ADC PARKS & GREENSPACE ARBORICULTURE

PLANNING APPLICATION: AB/119/14/TC

ADDRESS: 28 Martlets Court Queens Street Arundel BN18 9NZ

BRIEF DESCRIPTION: Fell 2 No Sycamore trees (T4 and T5 on plan) within the Arundel Conservation Area

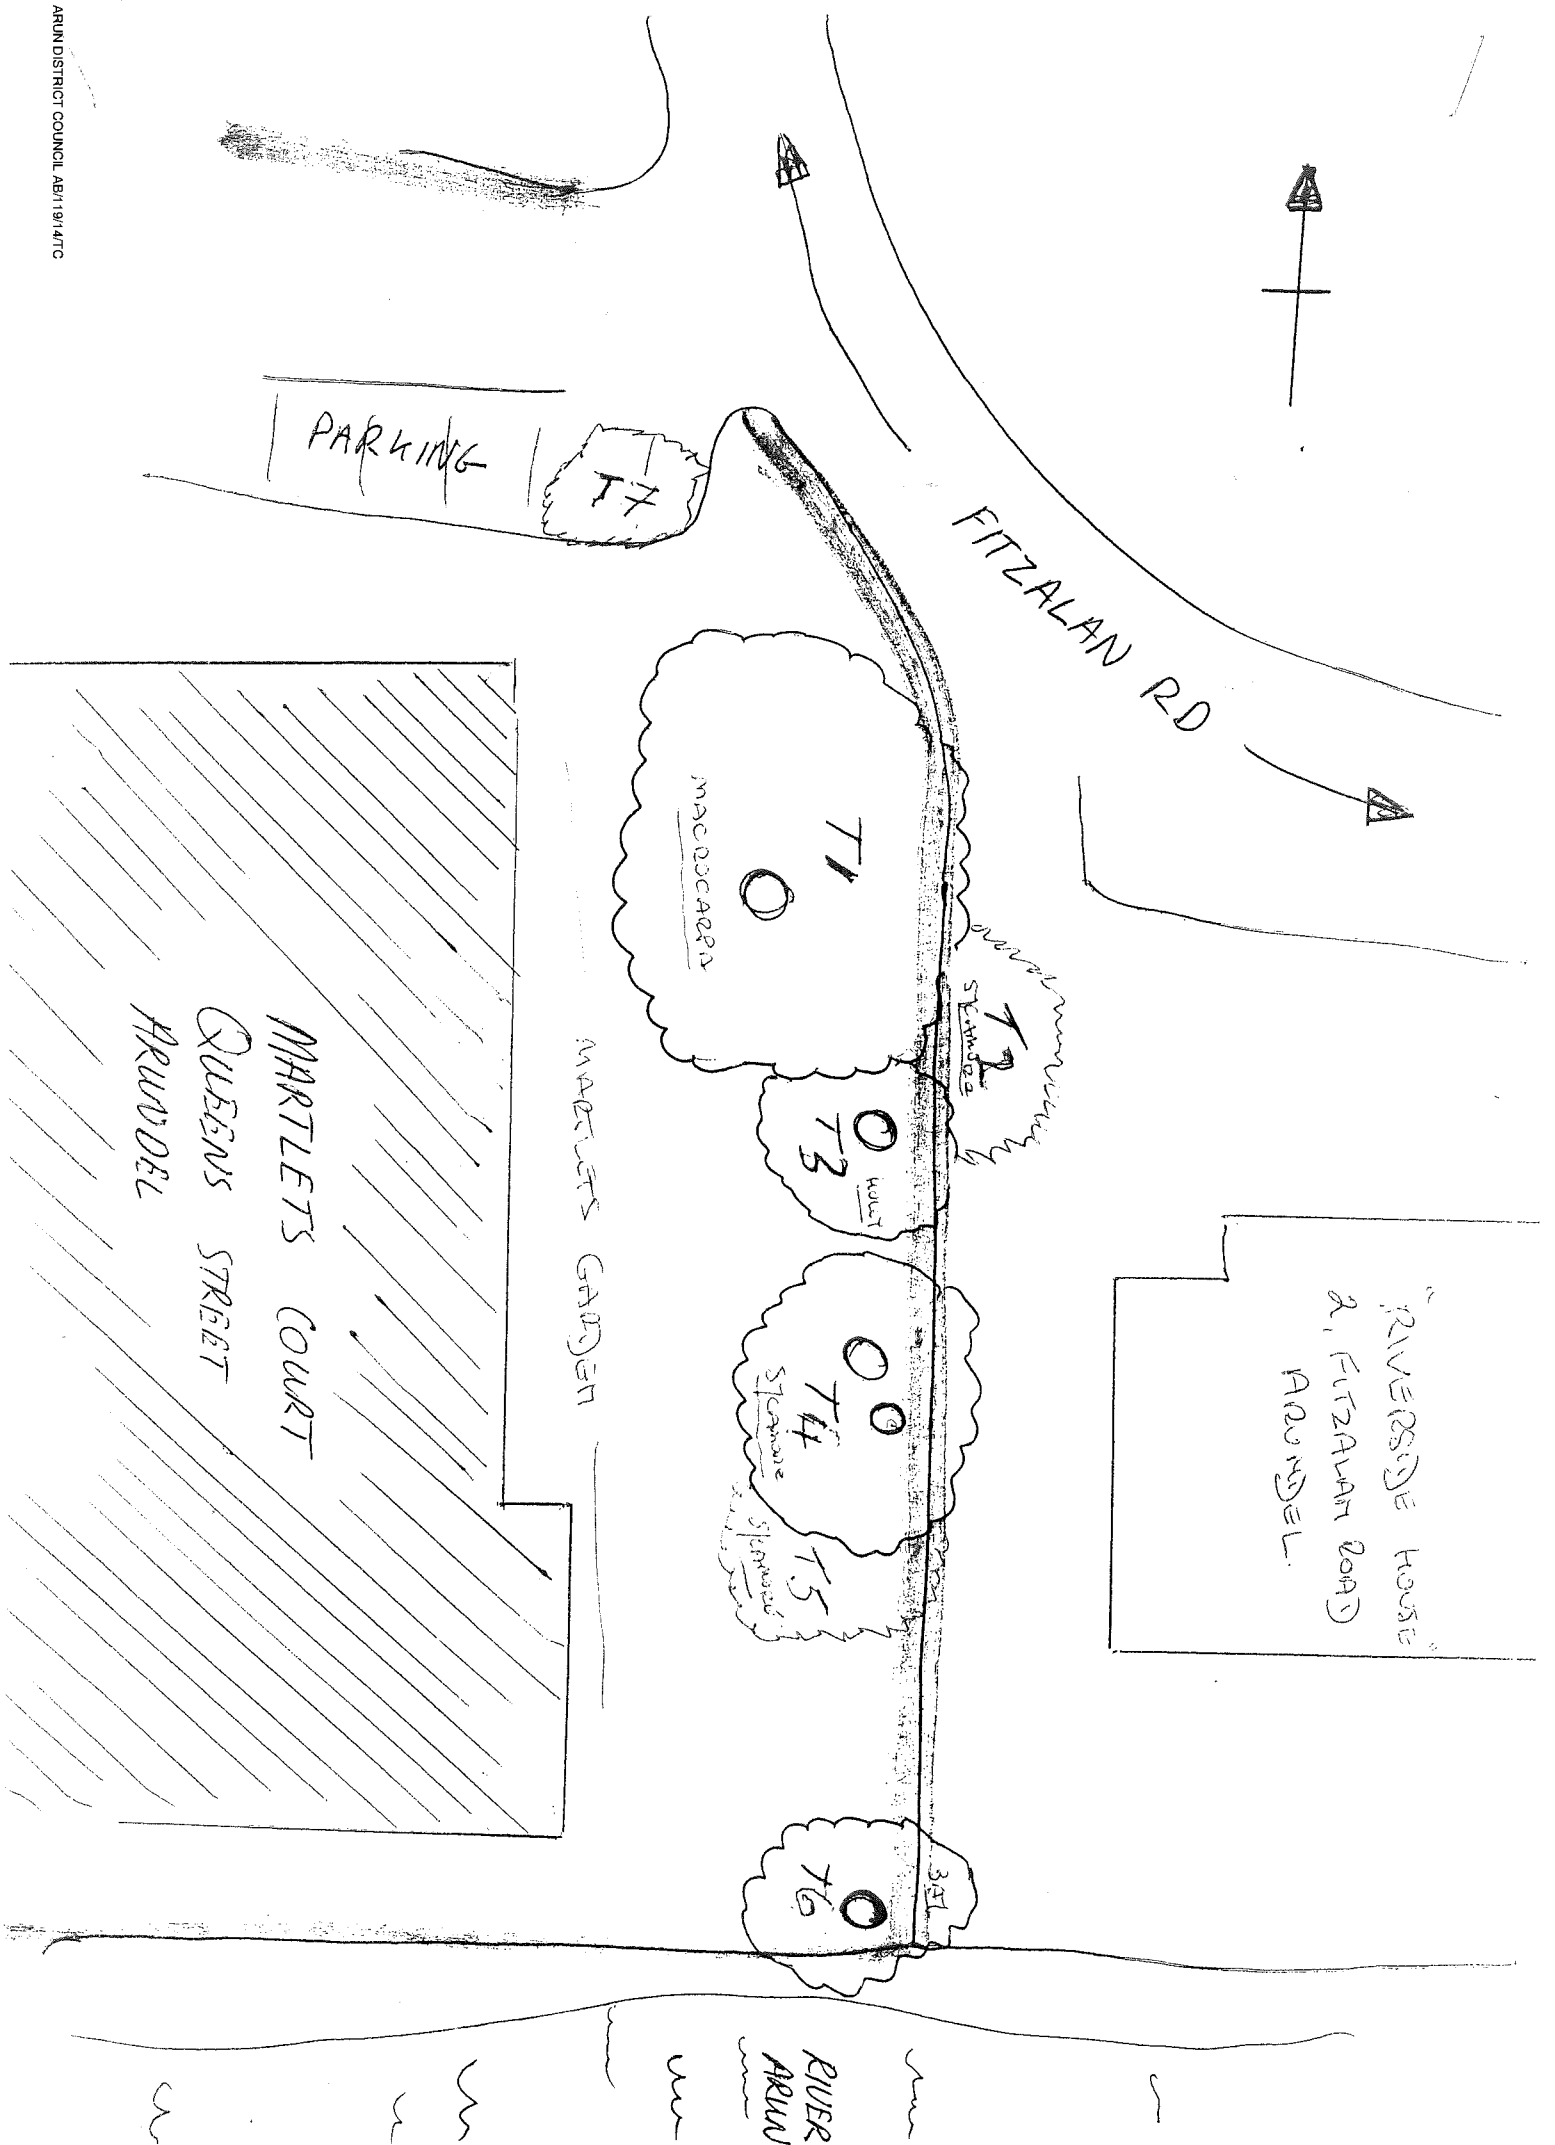
- Firstly, the application outlined two sycamores on site – I could only find one. There is an array of other broad-leaved trees on site – guessing this is a misidentification from the applicant.
- The outline tree is situated in the high amenity landscape of Arundel. This individual is near the centre of town, I can be seen by the public from the opposite of the river bank.
- The applicant has failed to provide any information/justification for the felling of this tree. From the site visit there was no visual evidence of any weaknesses/defects with this individual. Also this individual has a reasonable area for incremental stem increases.

- I would therefore like to object to the felling of this tree as there is no arboricultural justification for such an act.
